PLANNING CONSULTATION RESPONSE

Application No	2025/1077
Proposal	Change of use from dwellinghouse (Class C3) to 4-bed 4-person HMO (Class C4) (Amended Description).
Address	329 Midland Road, Royston, Barnsley, S71 4AZ
Date of Consultation Reply	13.01.26
Consultee	Stacey Fieldsend-Case Management Officer

2nd consultation response.

Drawing SCHEME PROPOSAL  
EXISTING AND PROPOSED FLOOR LAYOUTS Drawing No. P.100

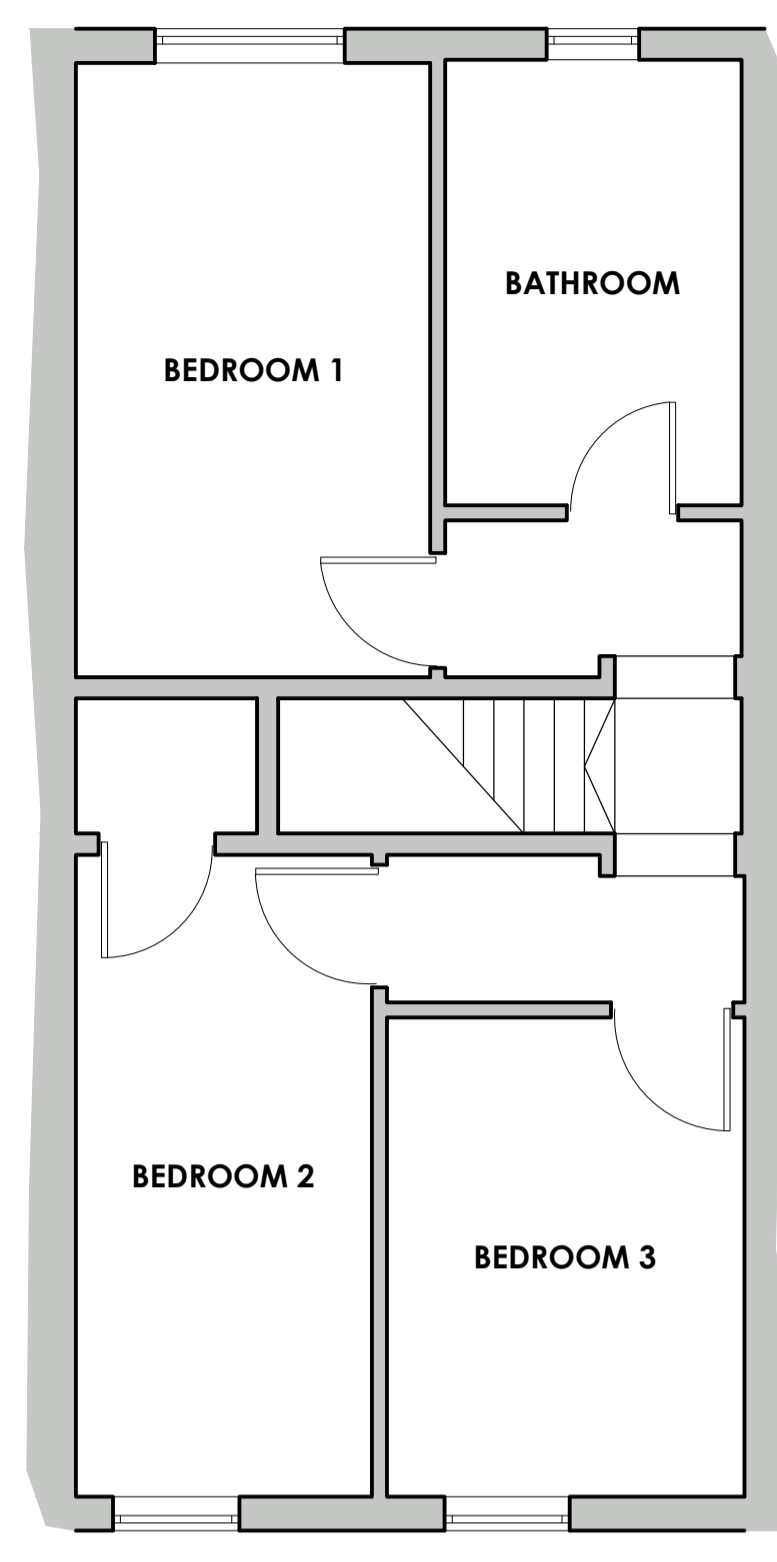
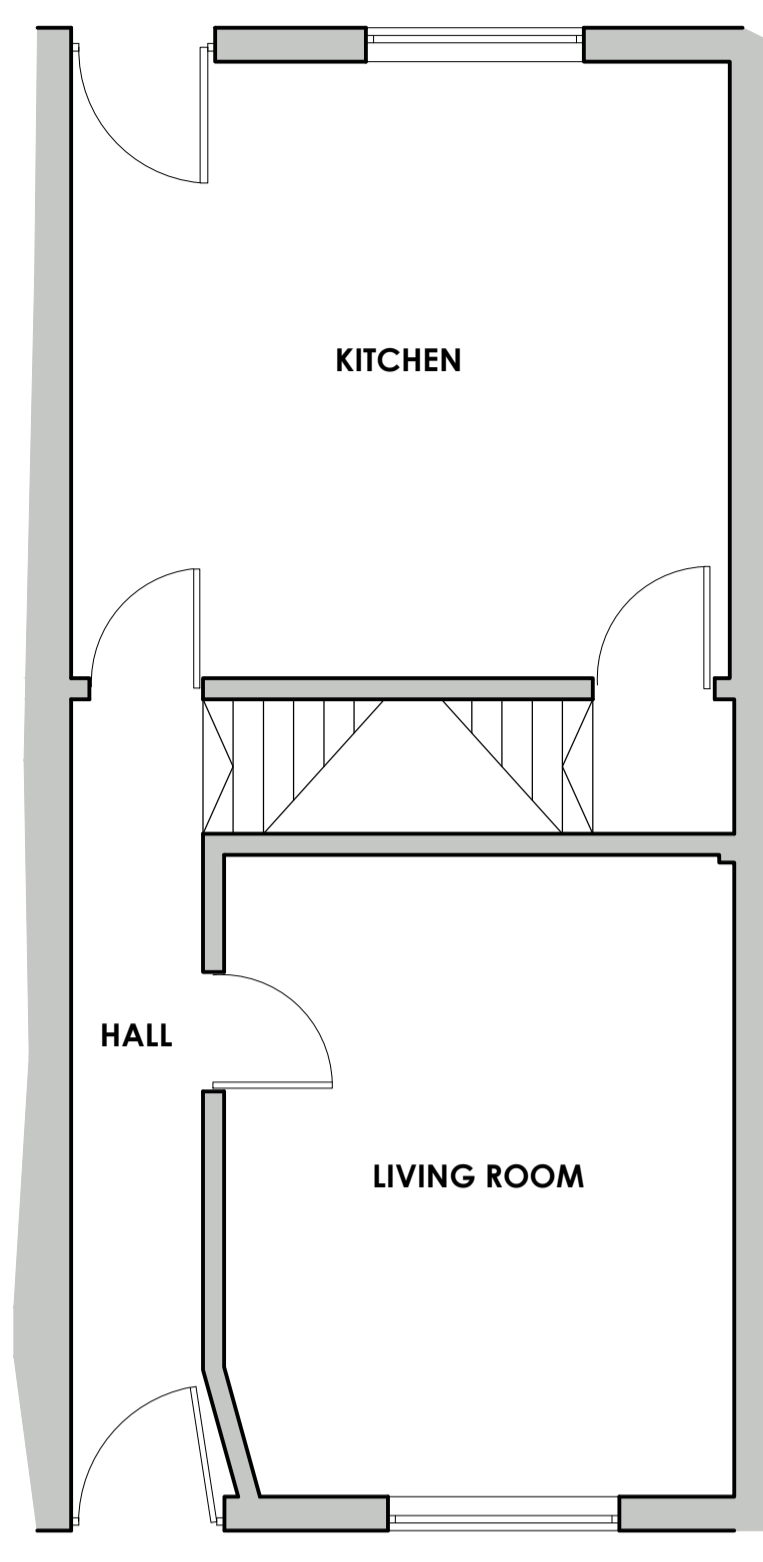
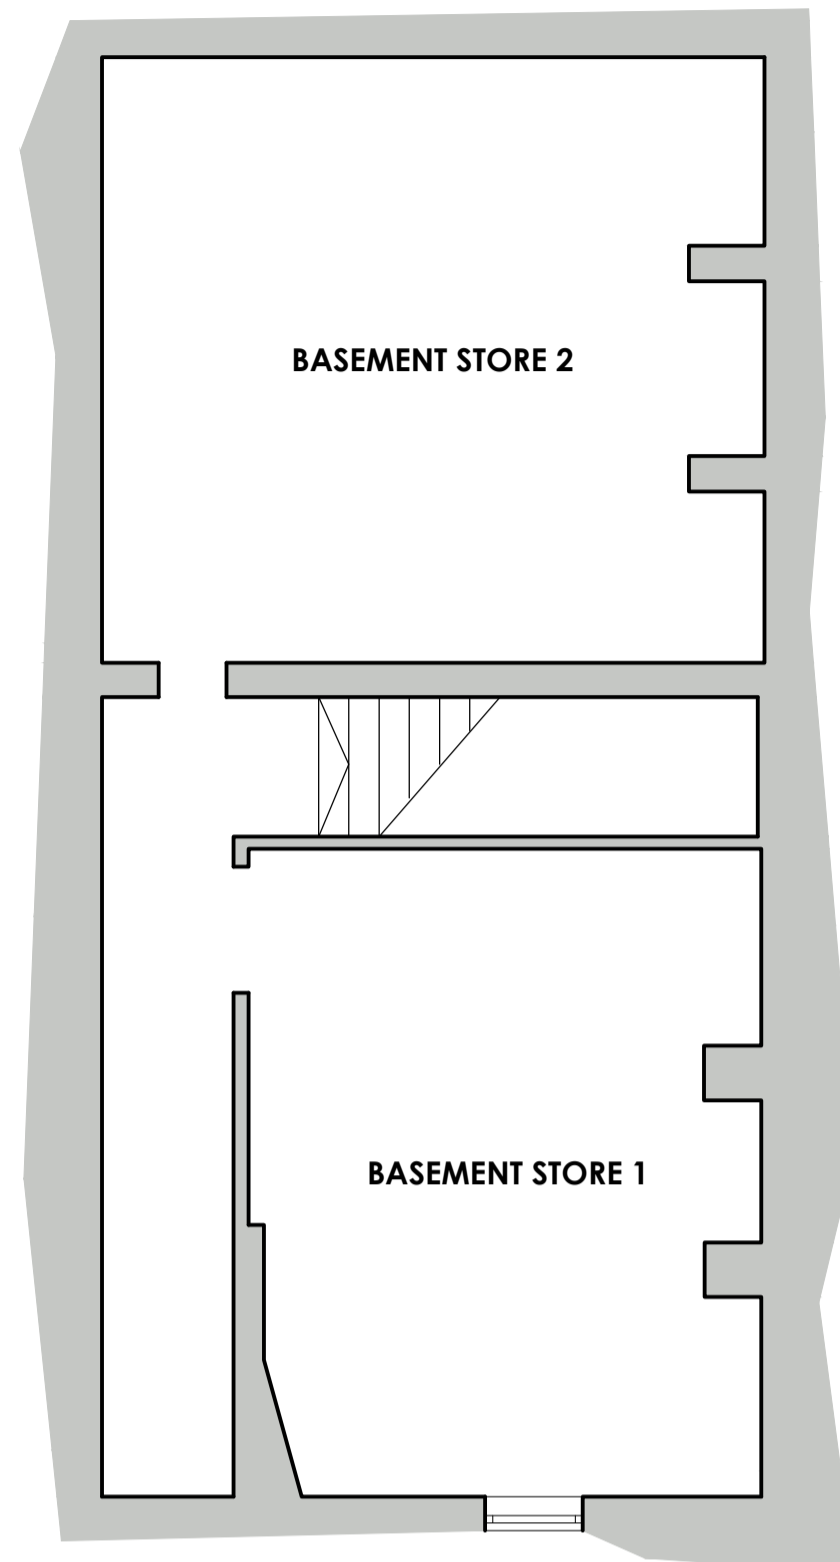
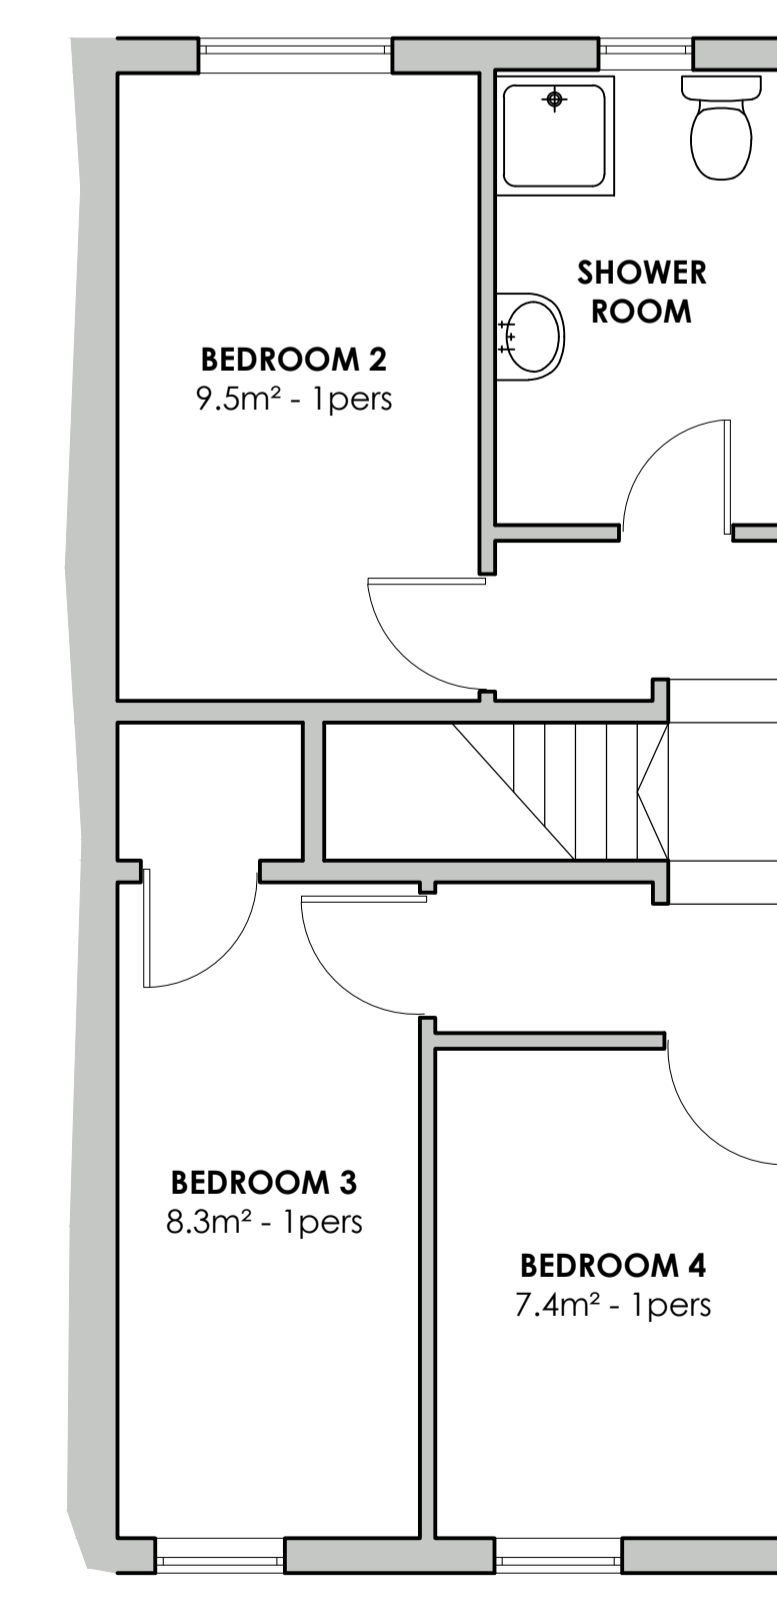
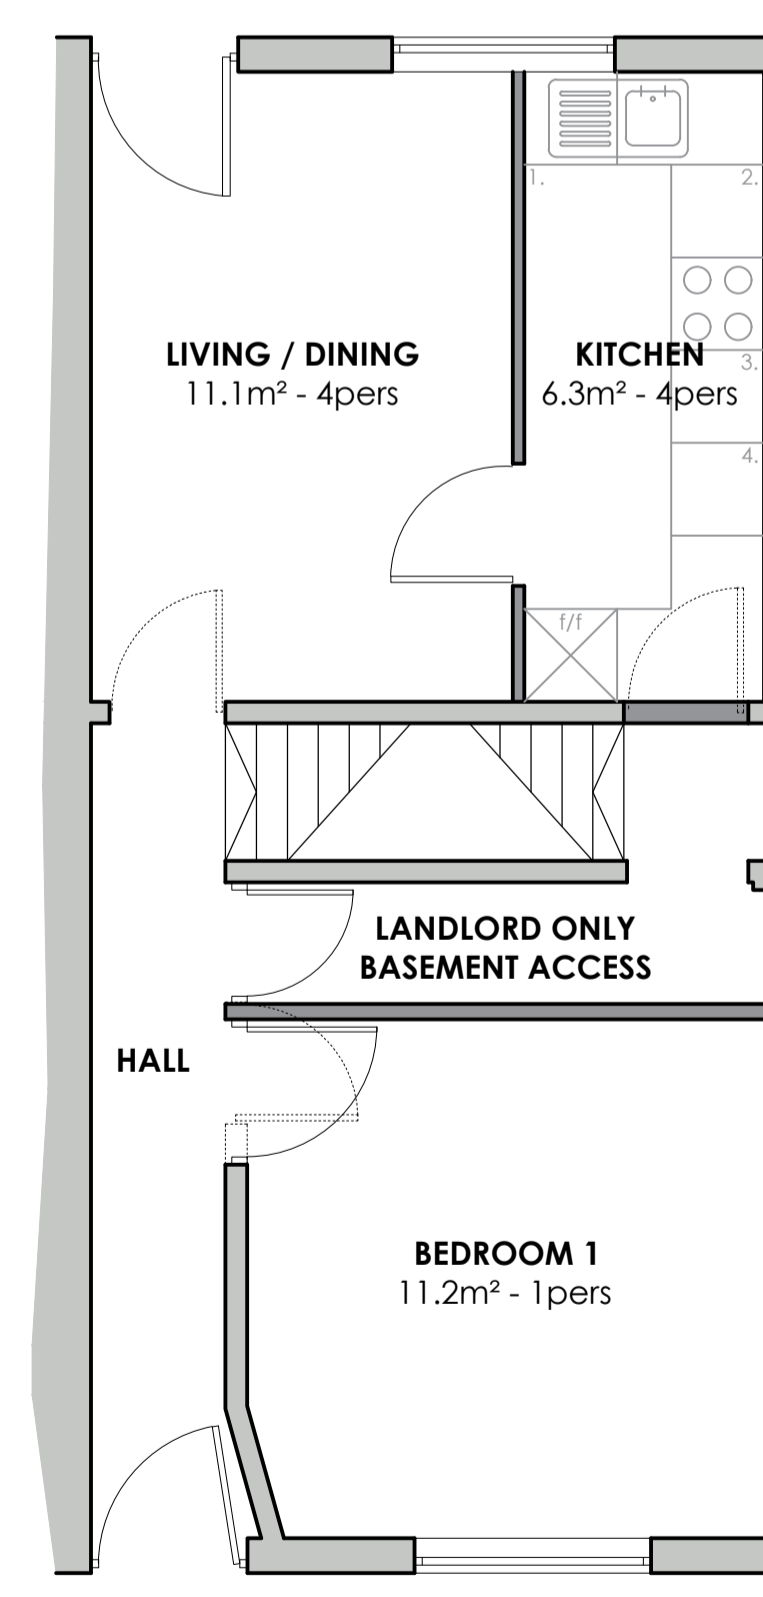
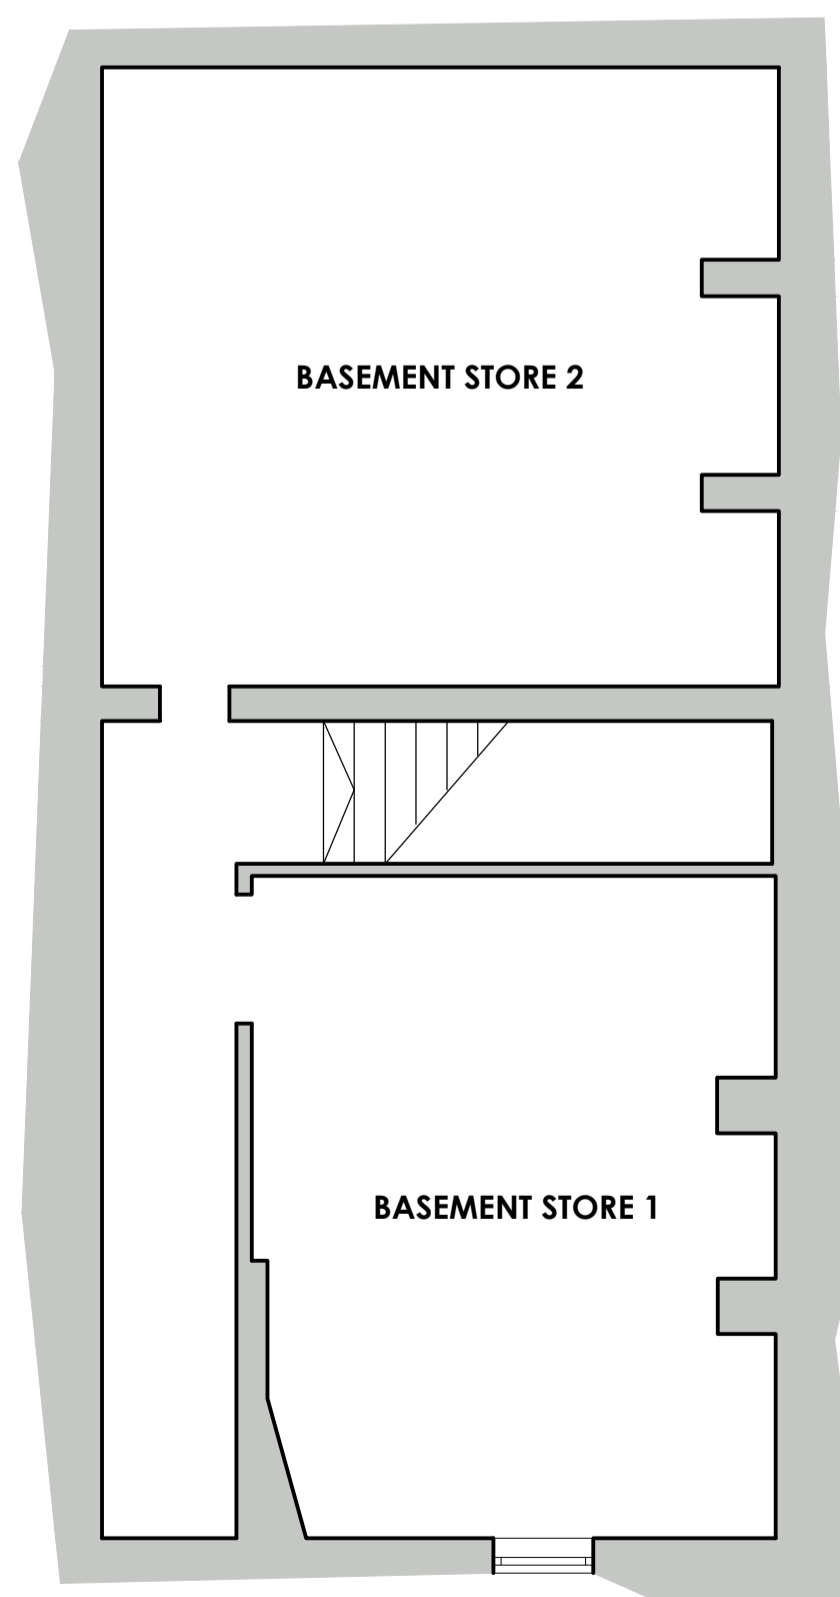
I have viewed the amended internal floor plans and have no objections to change of use to a four bed, four person dwelling house.

The ground floor back left room will remain a communal living/dining room.
The property will have a maximum occupancy of four people.

The kitchen will be a minimum of 6sq metres.
